03 January 2020

**Re: Technical Review Response to 12/10/2019 Letter  
Project Rodeo  
City of Colorado Springs, El Paso County, Colorado  
Langan Project No.: 620011104  
AR DP 19-00633, AR NV 19-00634, AR NV 19-00635**

**PARTIAL
FINAL
LANDSCAPE PLAN
7**

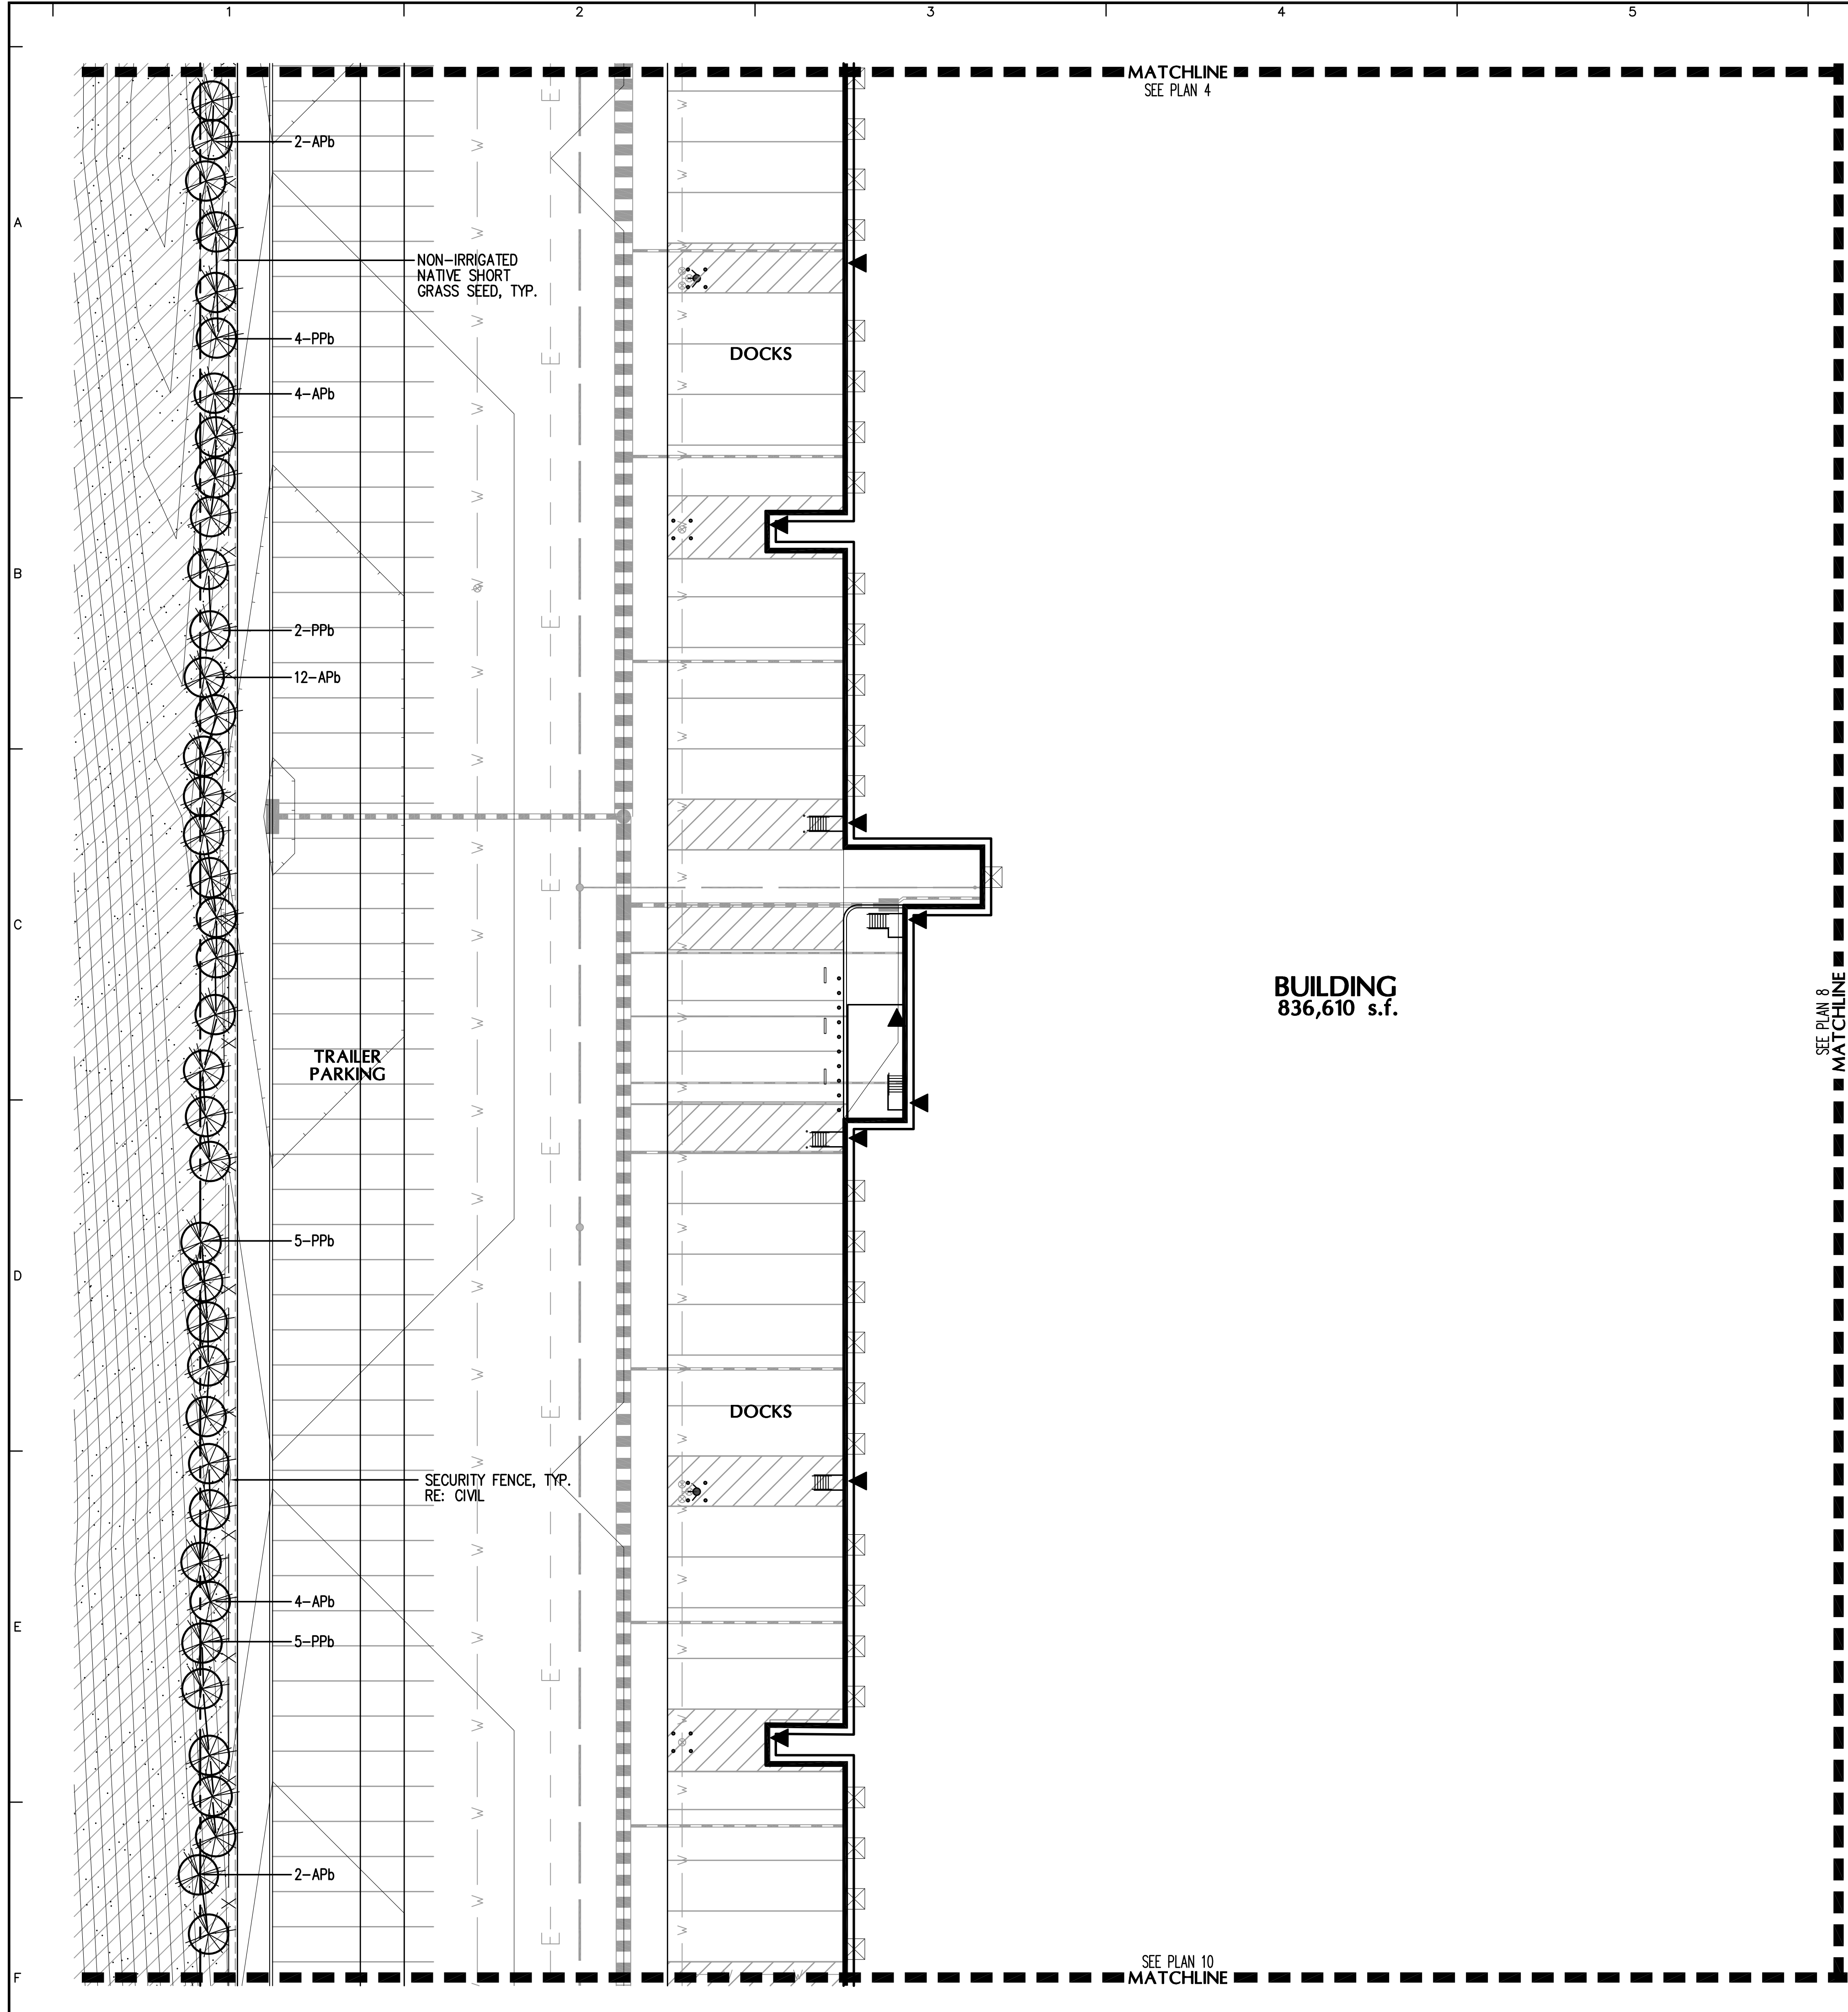
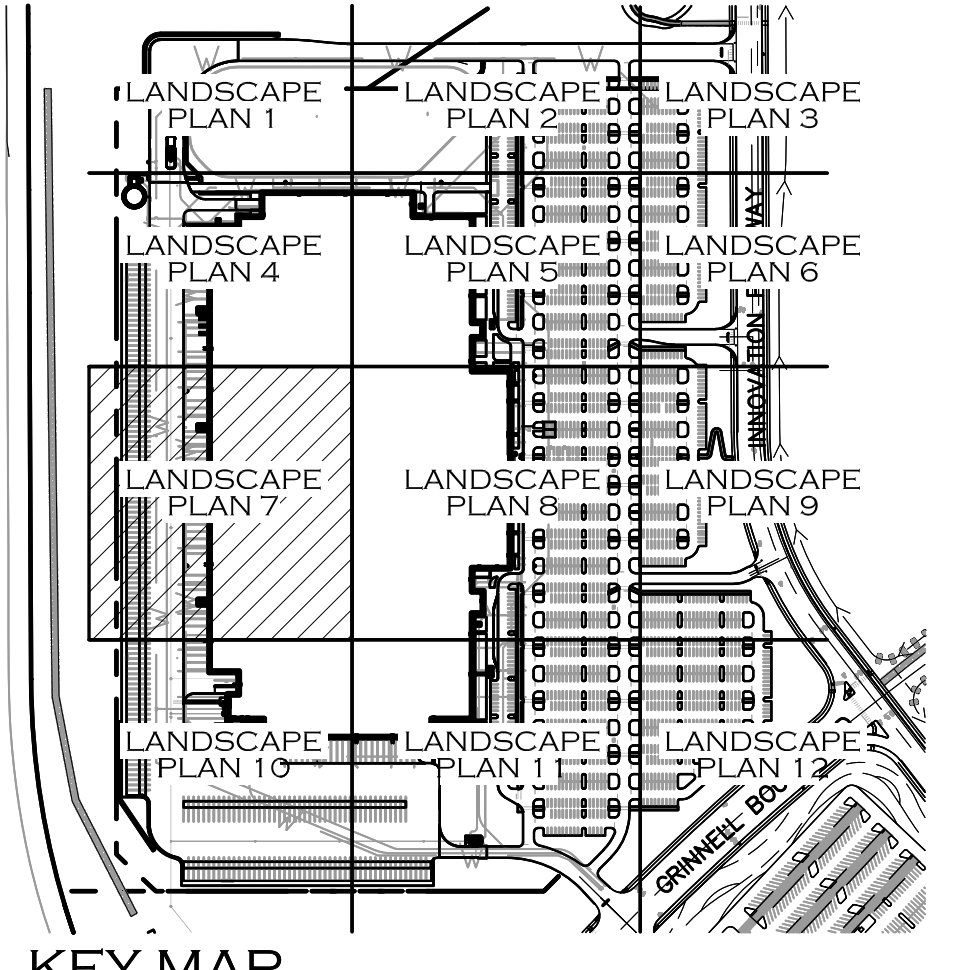
- a. *Building square footage of 836,610 differs from the square footage identified on sheet 3 of 823,173. Please update.*

**Response: Building footprint square footage has been updated on all sheets.**
